Planning Inspectorate Ref:
EN010112

Conwy County Borough Council Ref:
ENQ/31314

**Application by Awel y Môr Offshore Wind Farm Limited for an Order Granting
Development Consent for the Awel y Môr Offshore Wind Farm project**

Written Representation by Conwy County Borough Council

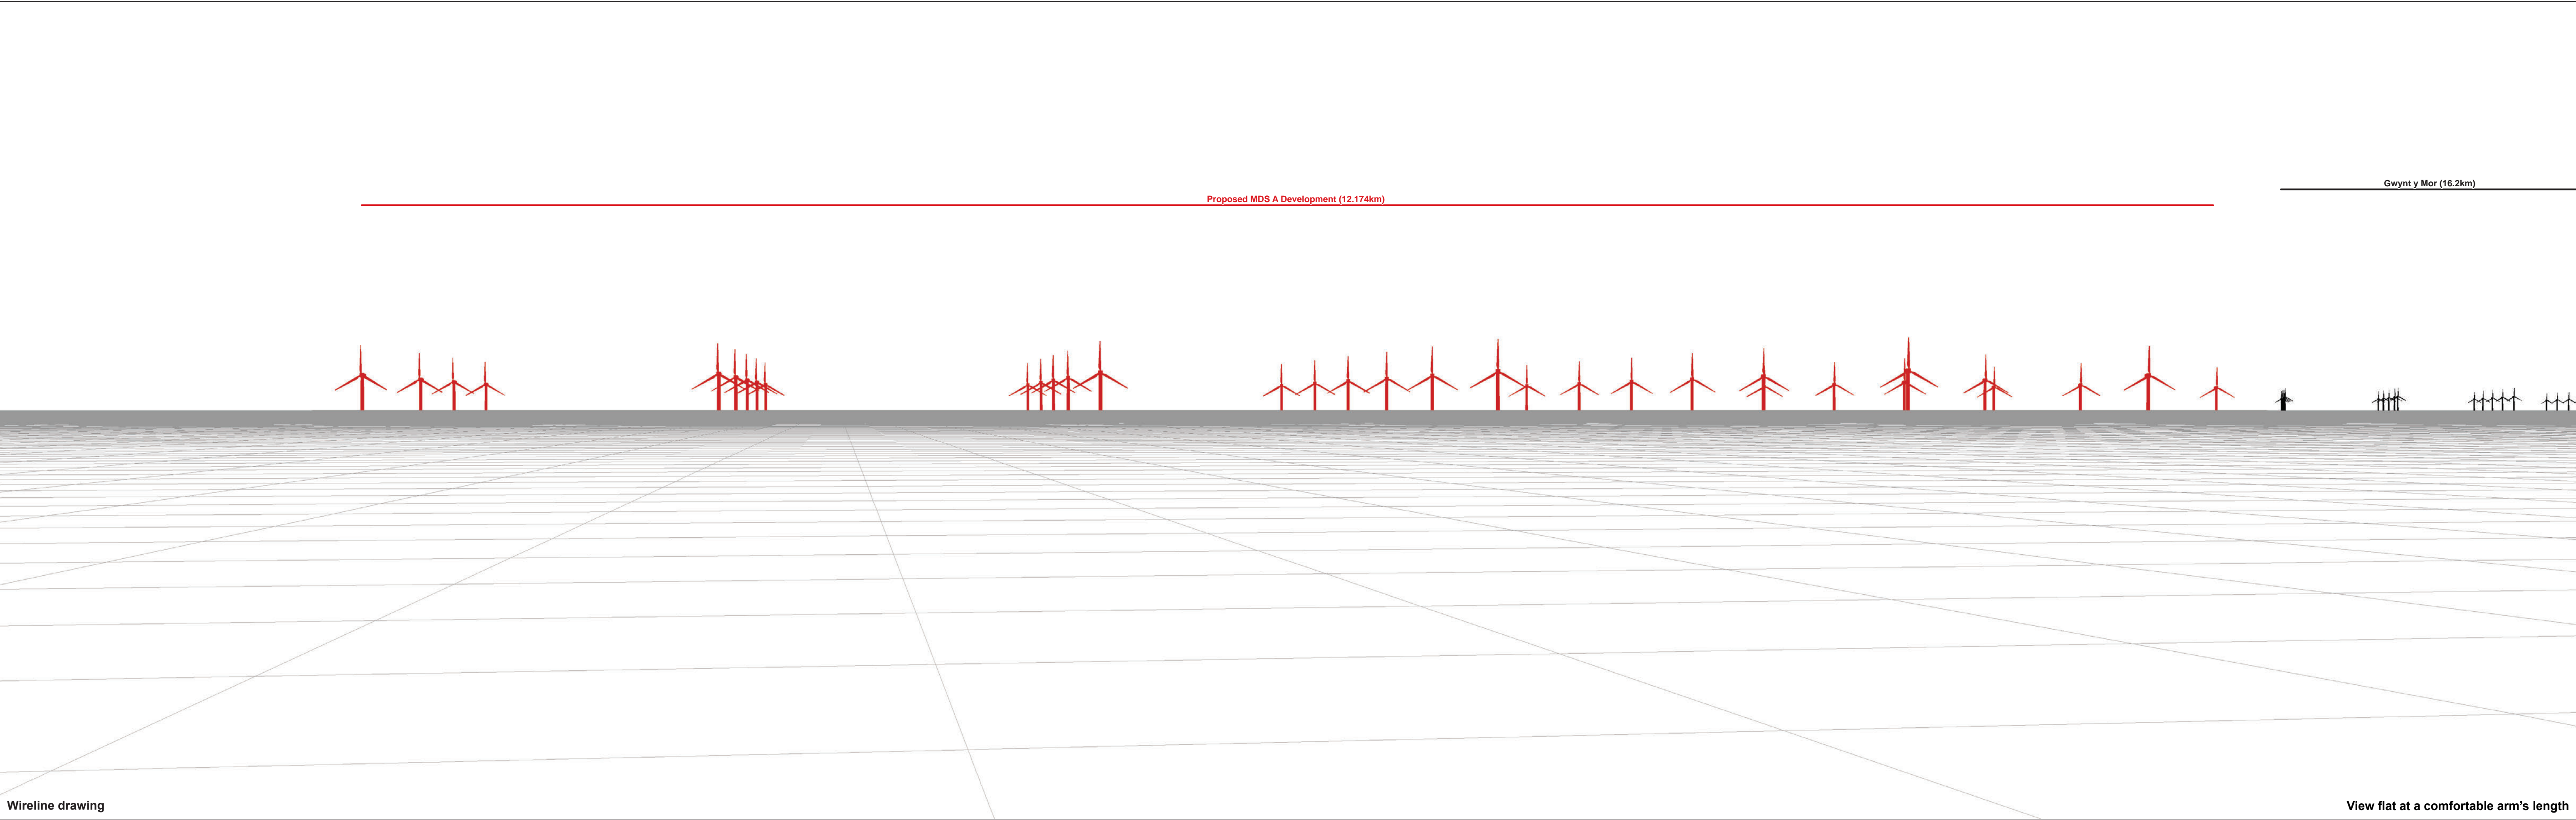
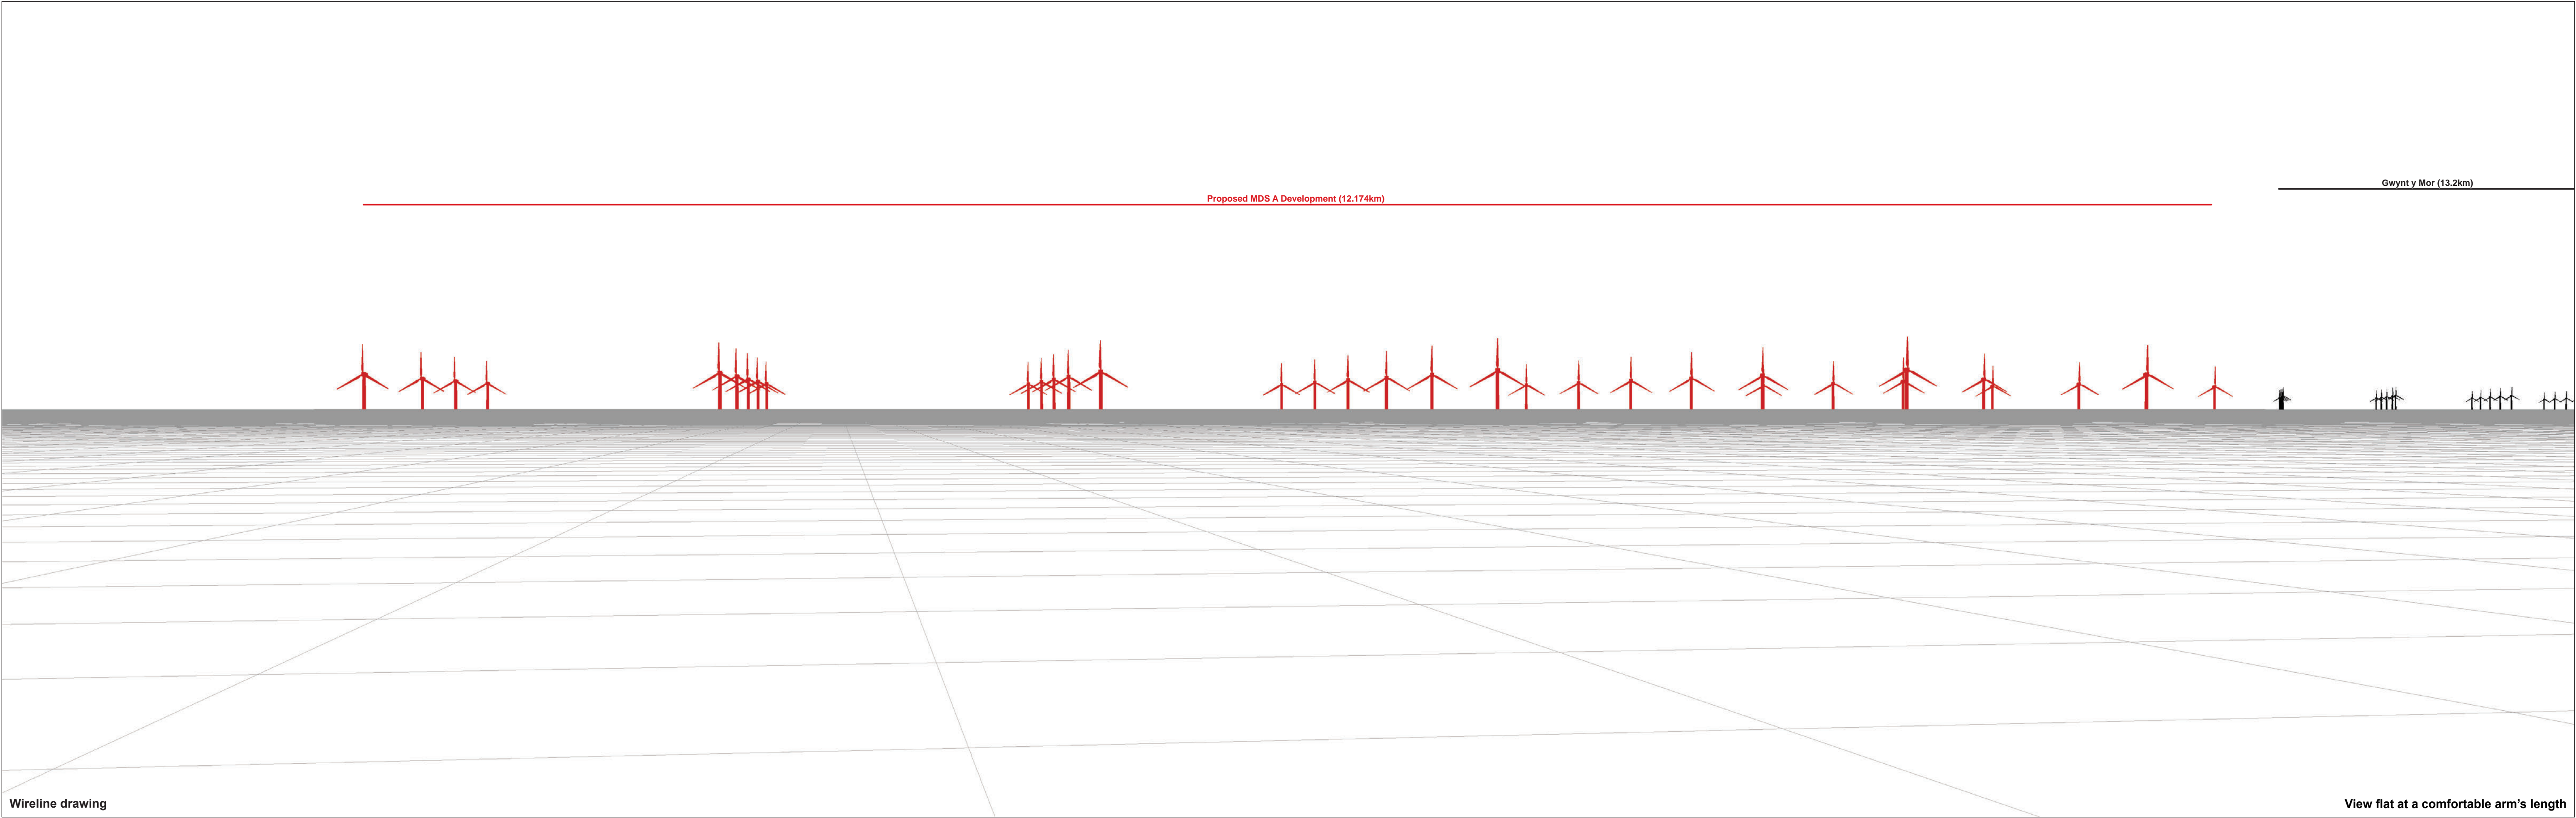
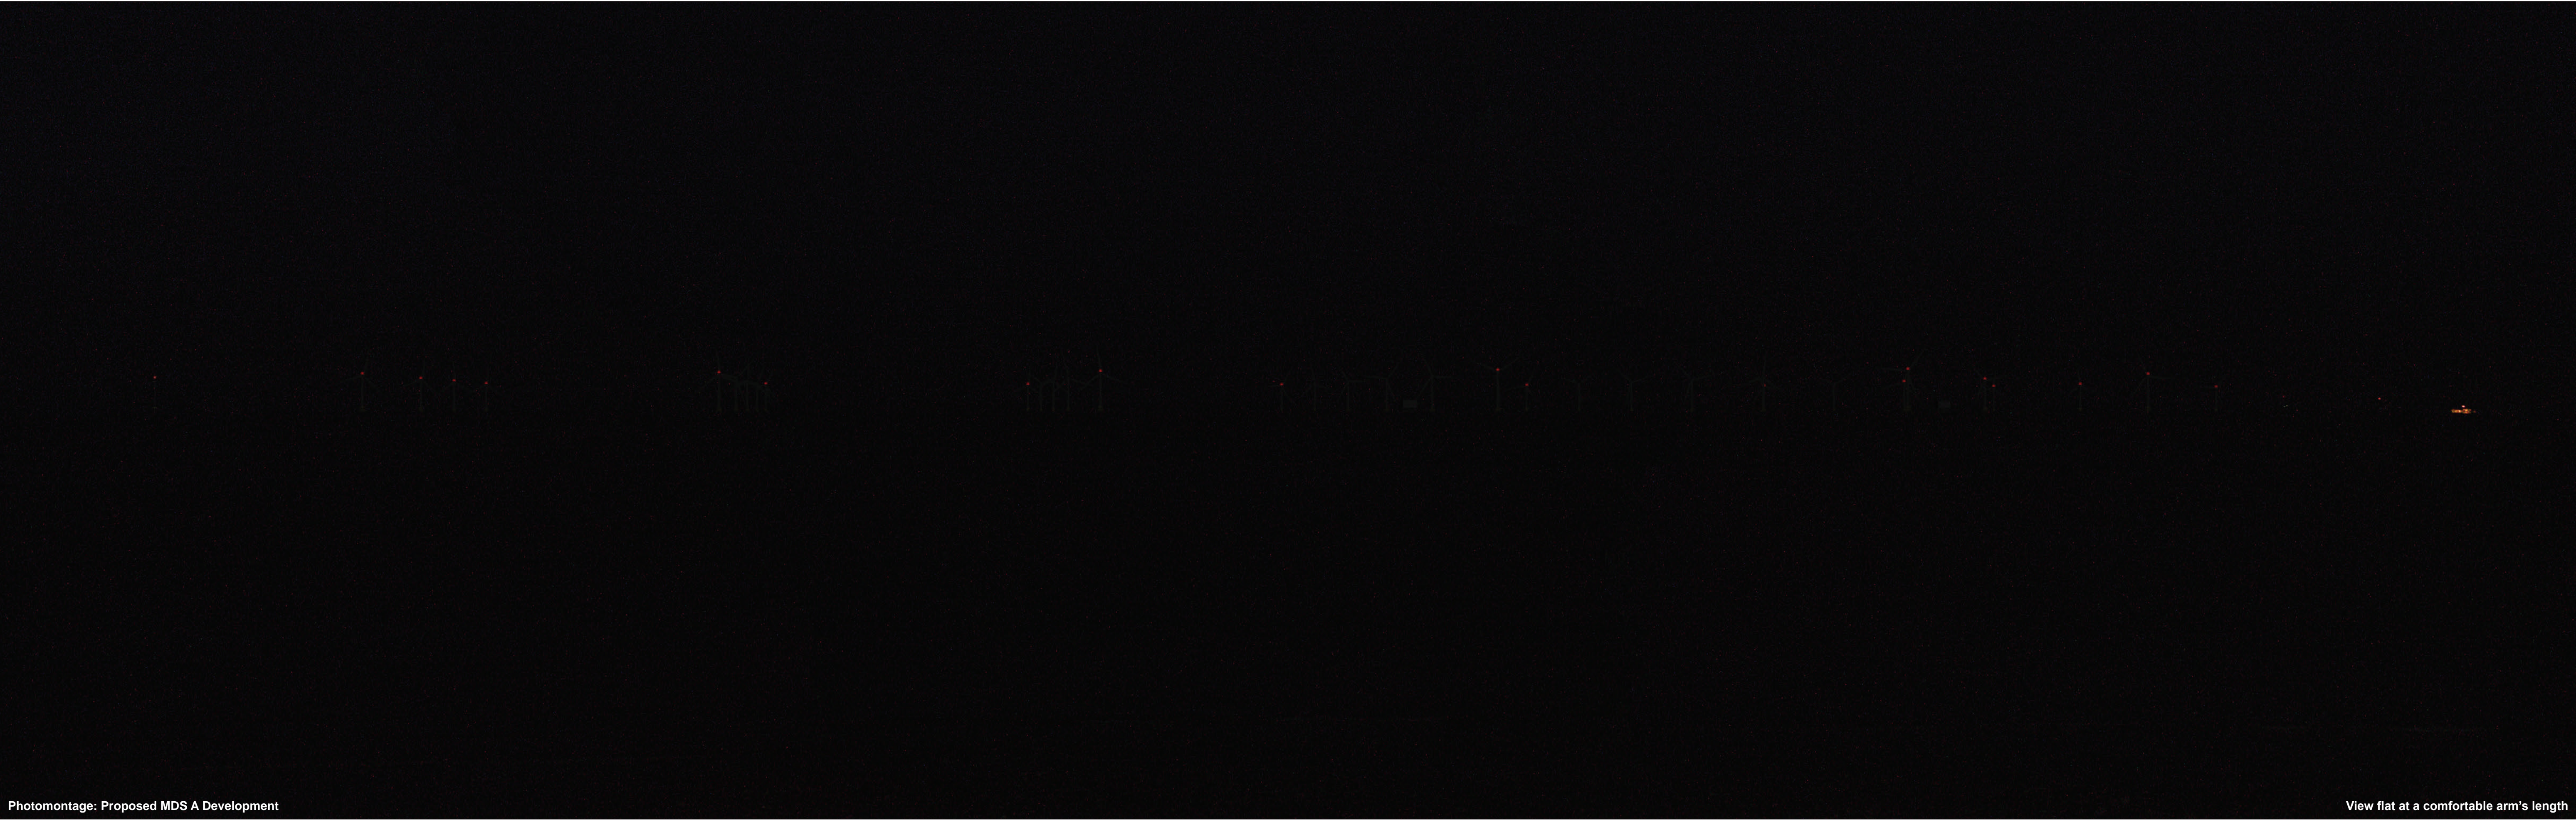
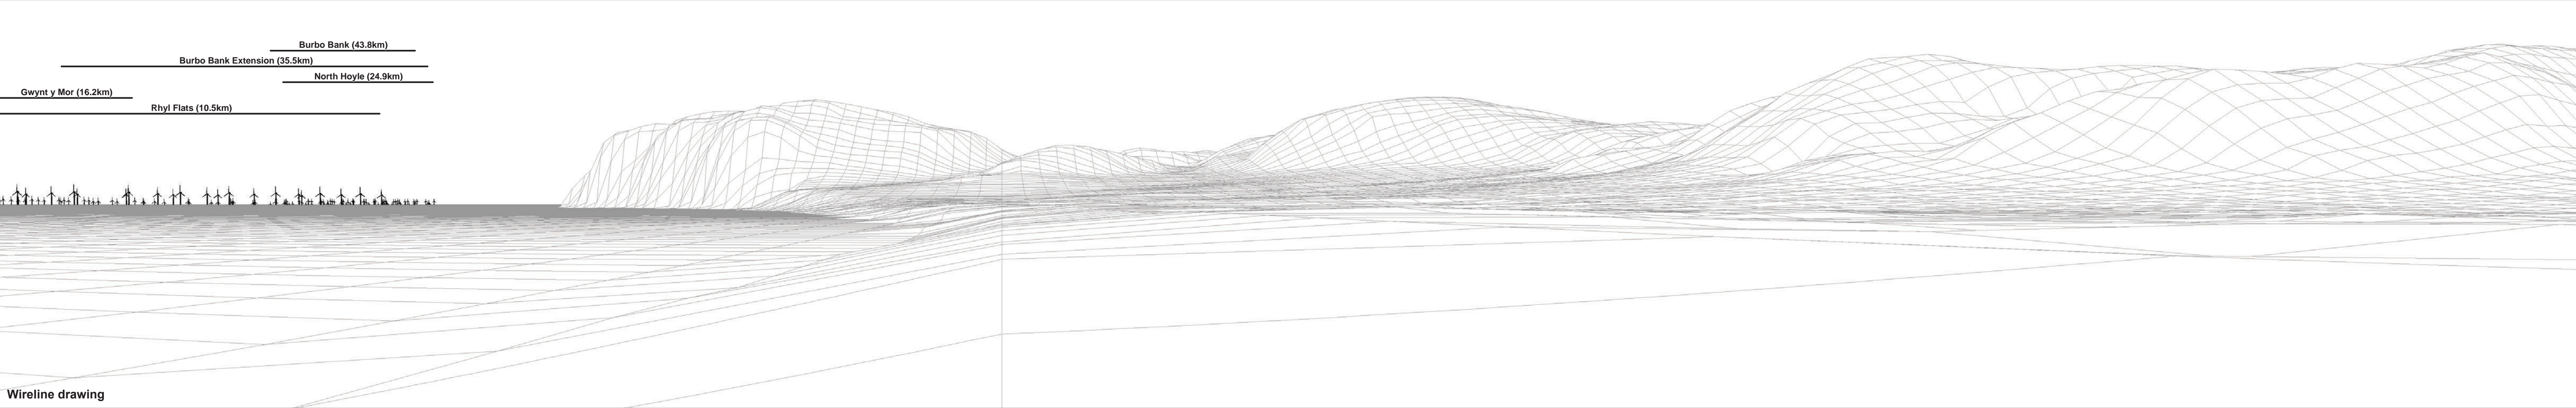
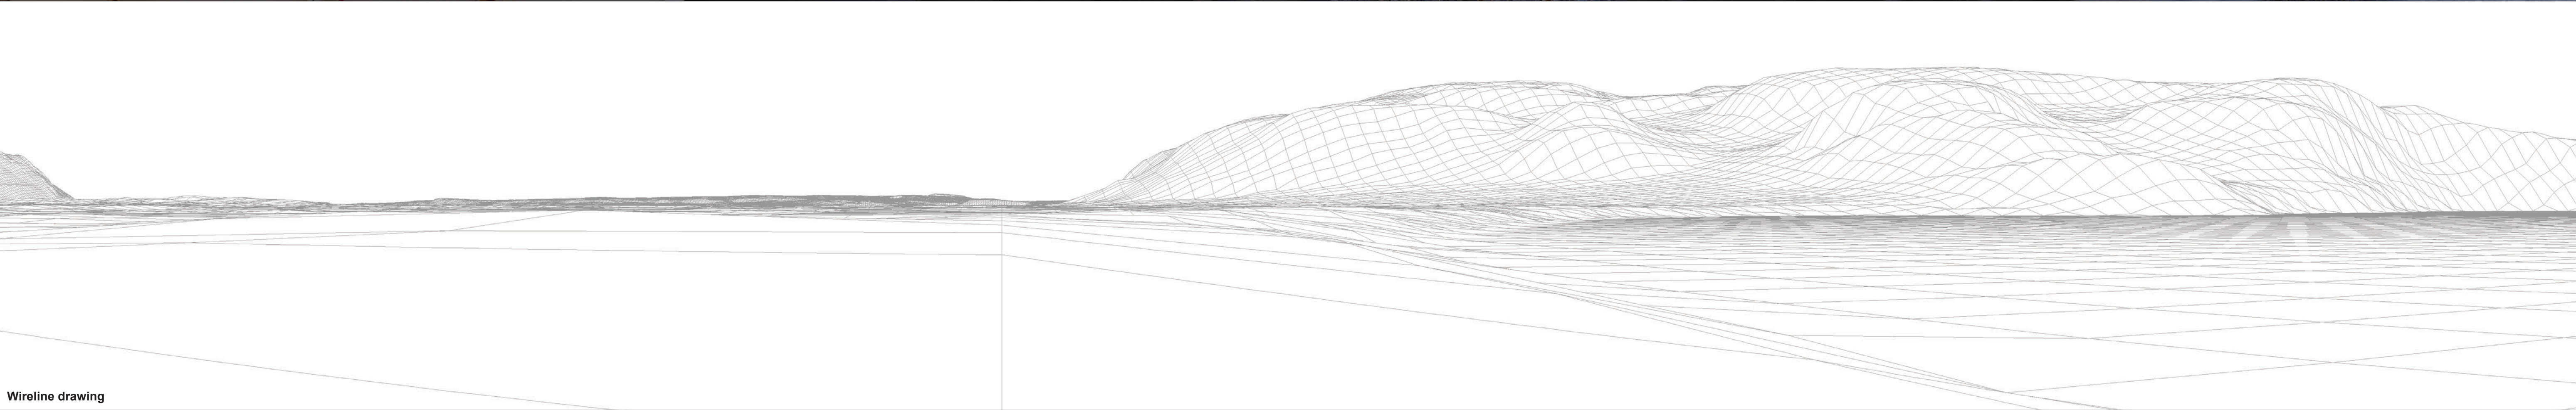
Figure 84c and 84h: Llandudno Promenade near Venue Cymru (12.174km)
